LOVELADY & ASSOCIATES  
7408 Morrow Ave. N.E.  
Albuquerque, NM 87110  
(505) 883-7973

RE: DRAINAGE PLAN FOR AN ADDITION TO MARTIN J. VIGIL BUILDING. (J-14/D-91)  
ENGINEER'S STAMP DATED JULY 31, 1990.

GRADING AND DRAINAGE PLAN
NEW BUILDING ADDITION FOR
MARTIN J. VIGIL
1315 SECOND STREET N.W.
ALBUQUERQUE, NEW MEXICO

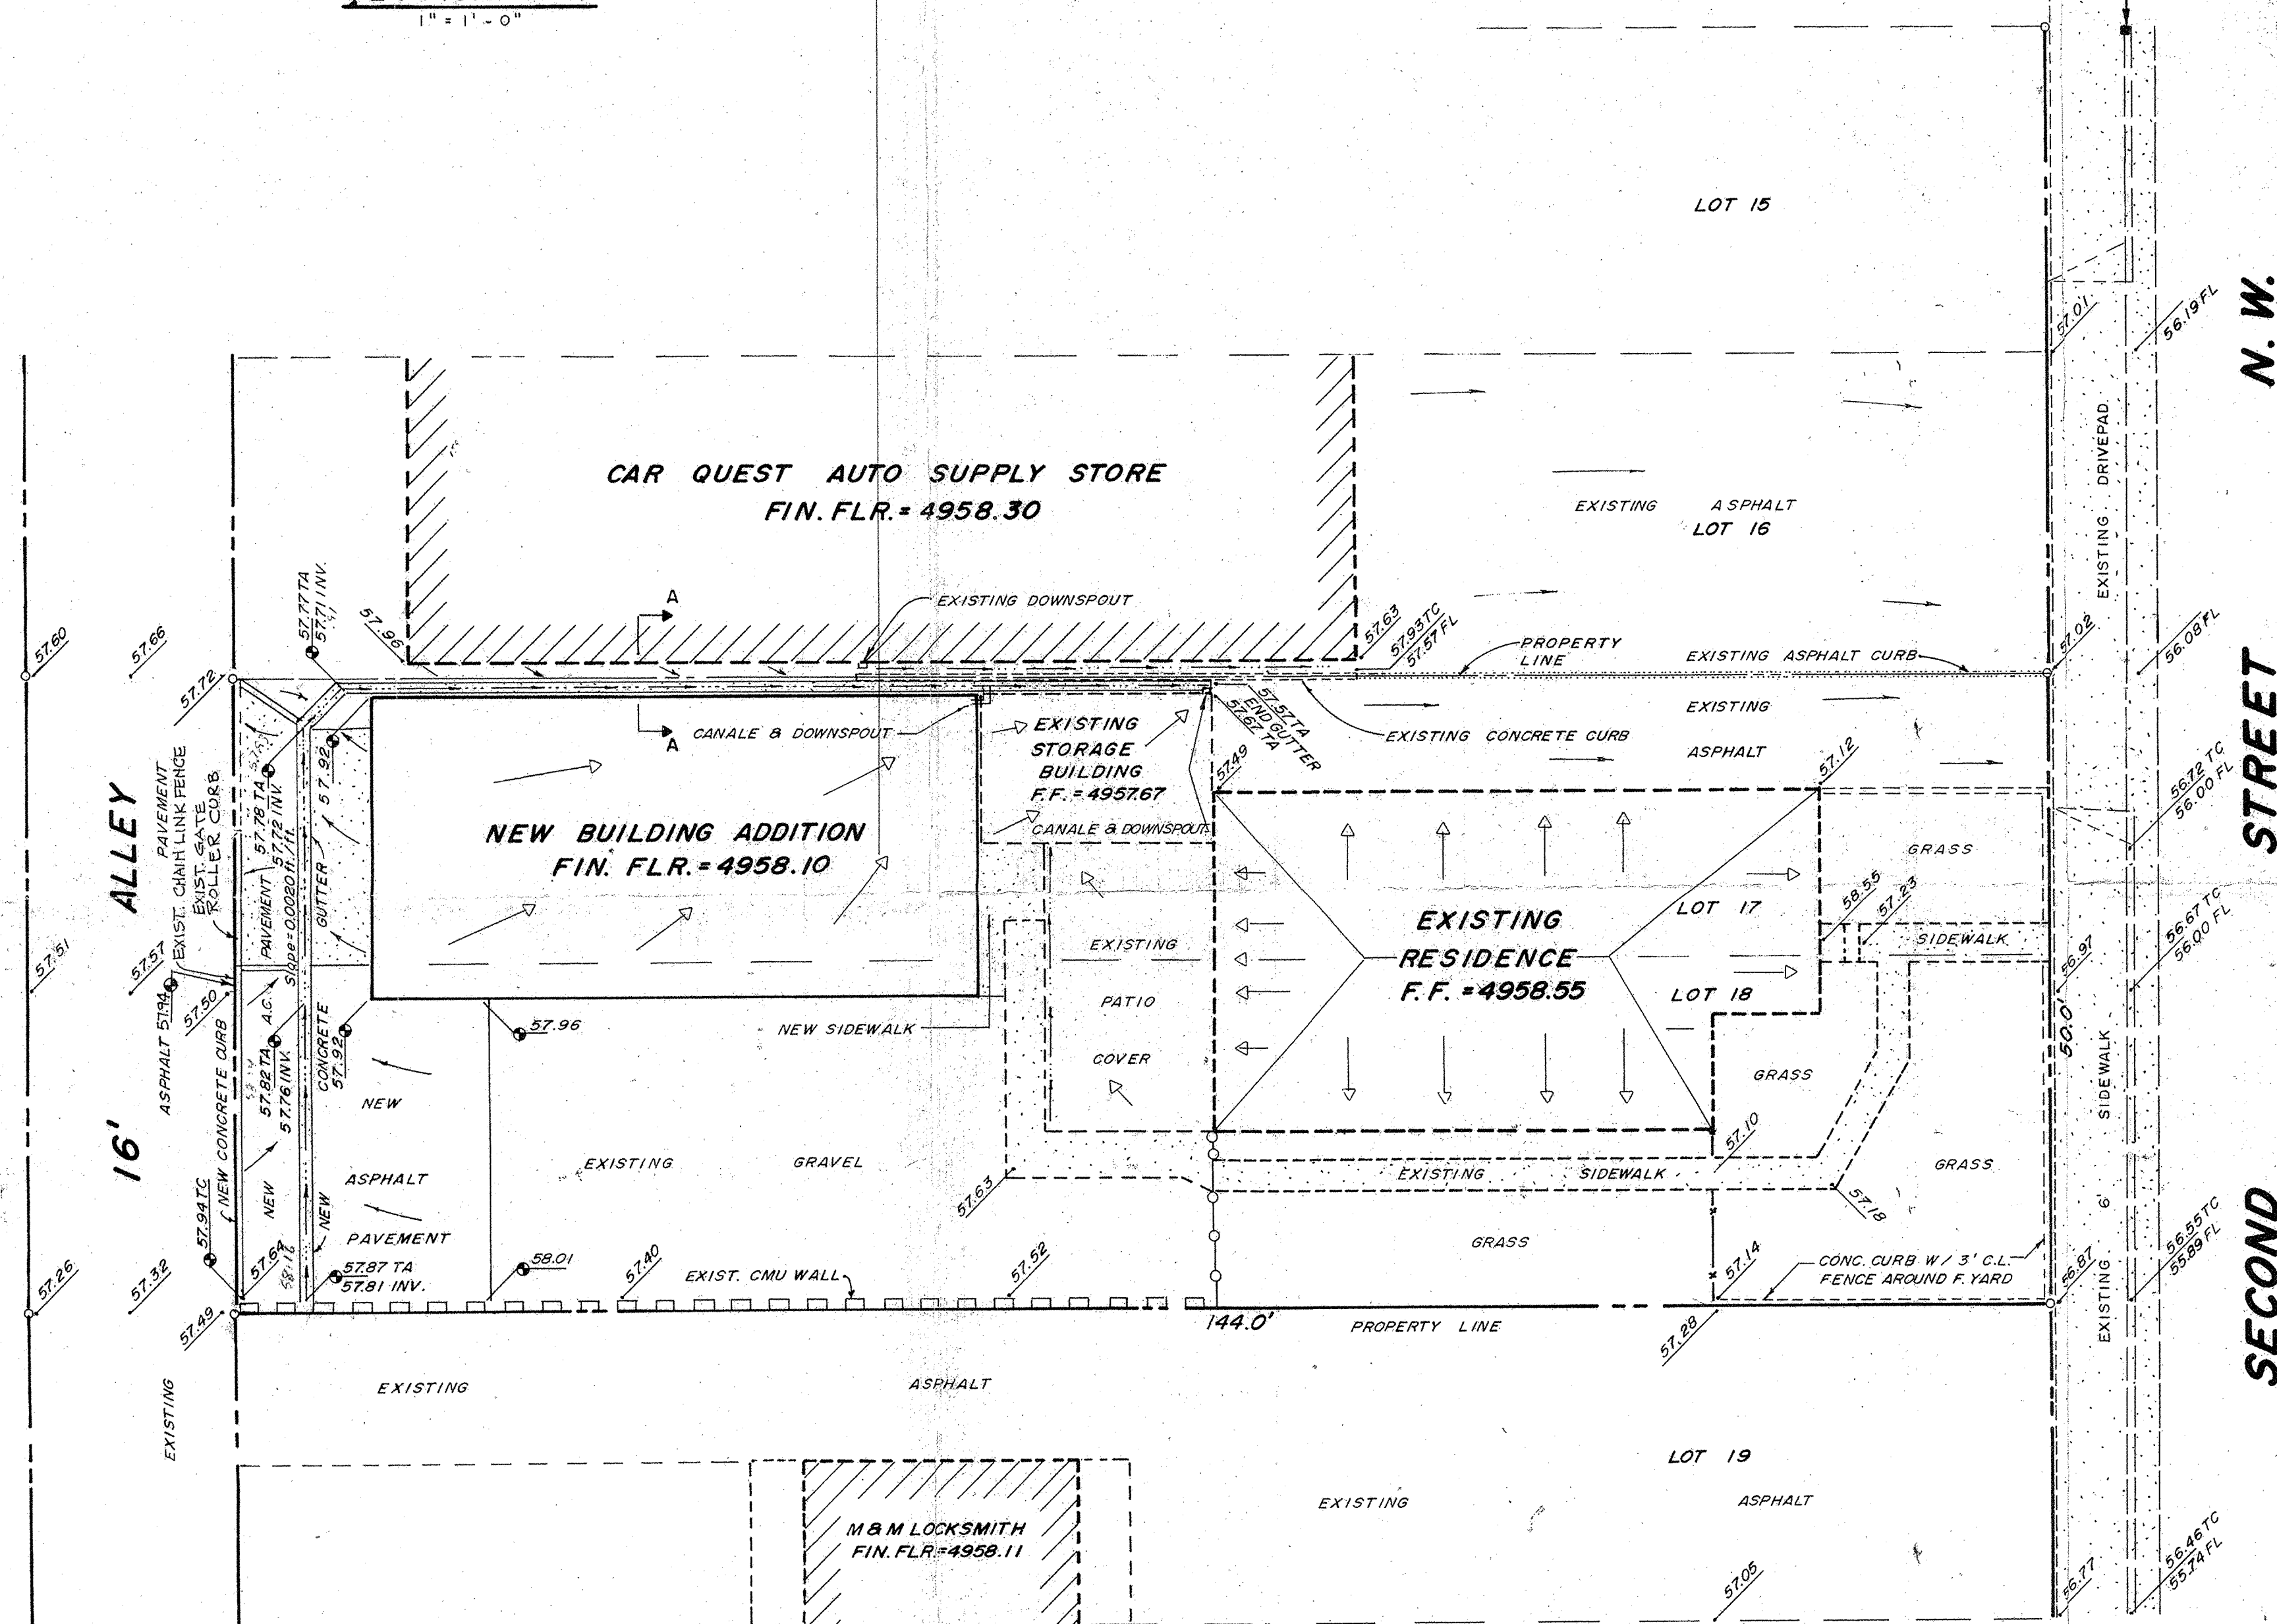
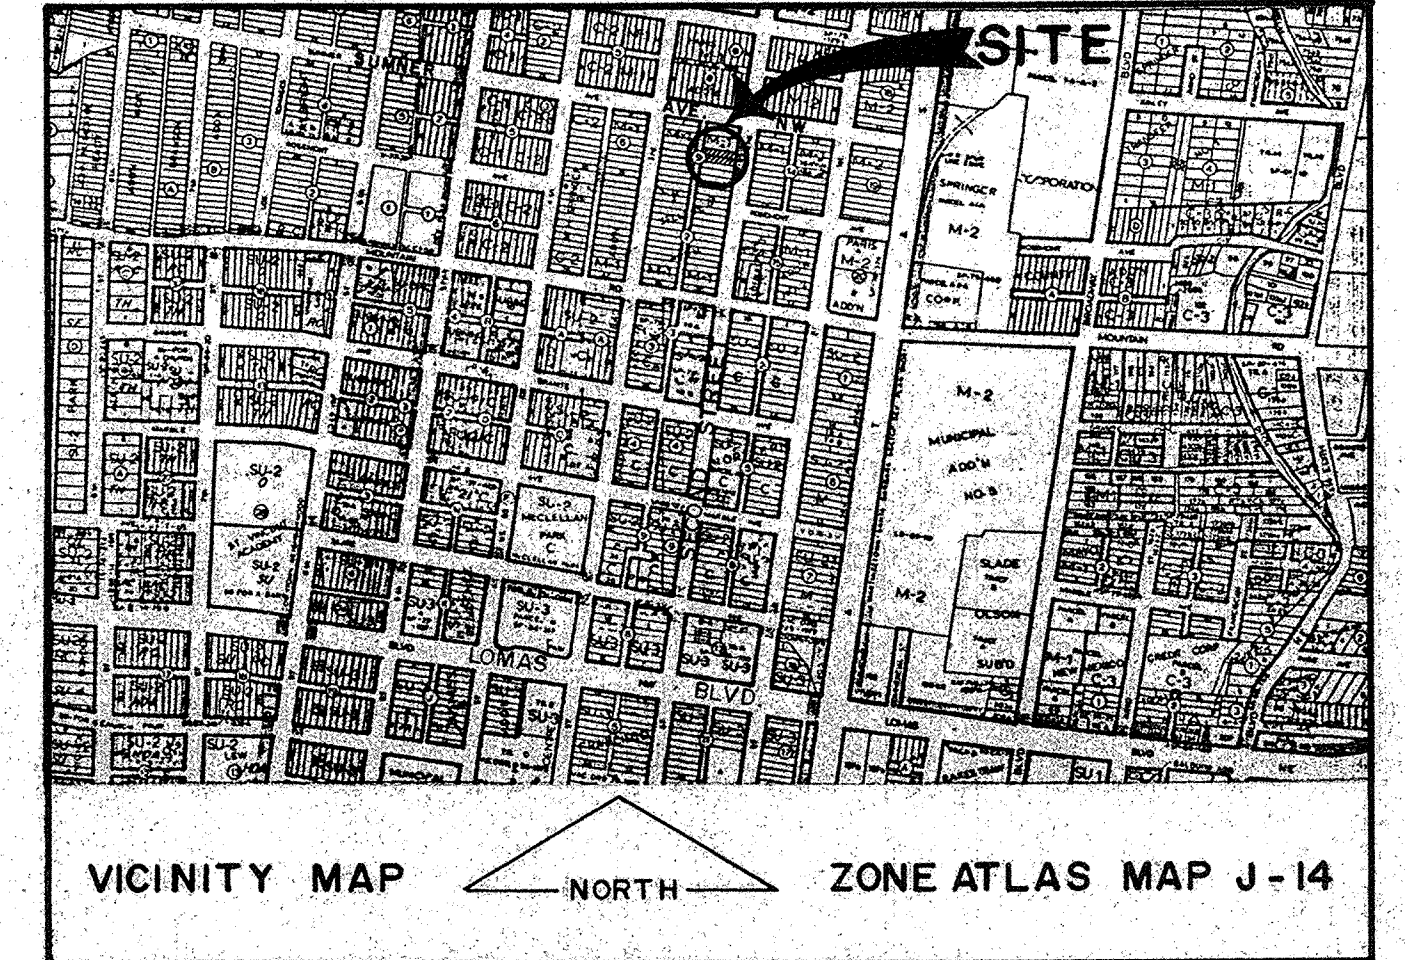
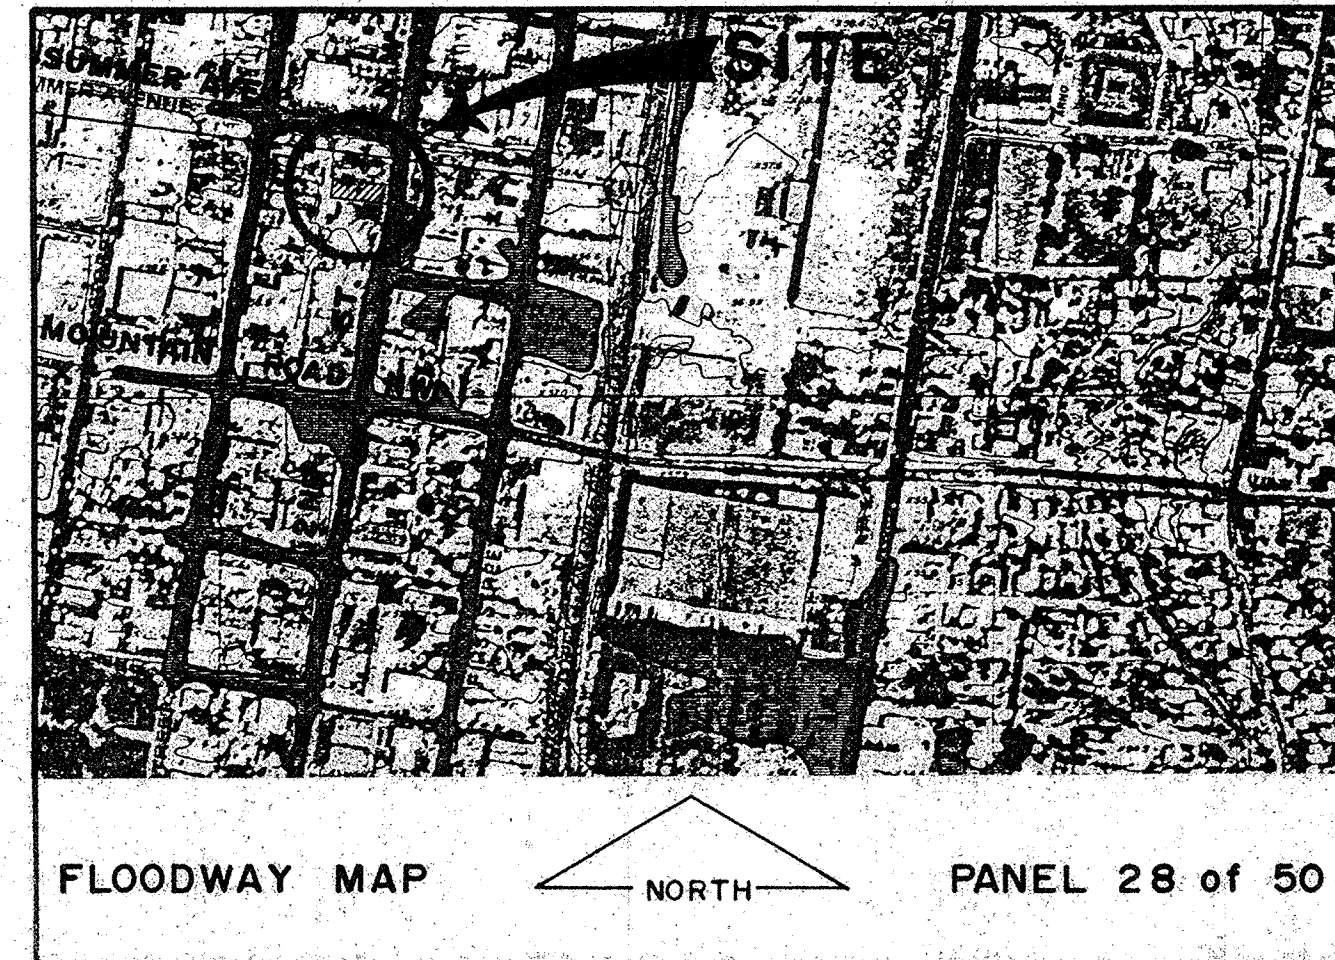
With regard to your letter of August 10, 1990, increasing the slope to 0.0050 ft./ft. will require the finish floor to be approximately 0.4' higher which the owner feels is unacceptably high. From elevations taken in the alley, it is evident that runoff from the site would not be conveyed by the alley to the closest public street. In discussion with Bernie Monyoya, it was agreed that a grade of 0.0020 ft./ft. would be acceptable on a project of this scale provided the owner holds the City of Albuquerque harmless in the event that construction results in "bird baths" or in the event that other damages result from the use of a substandard slope.

I, Martin J. Vigil, owner of property at 1315 Second Street N.W., hold the City of Albuquerque harmless for any and all damages that may be sustained by my property as a result of constructing the drainage swale at a substandard slope.

Therefore, the owner has agreed to sign the hold harmless statement below. If you have any questions or require additional information, please do not hesitate to contact me.
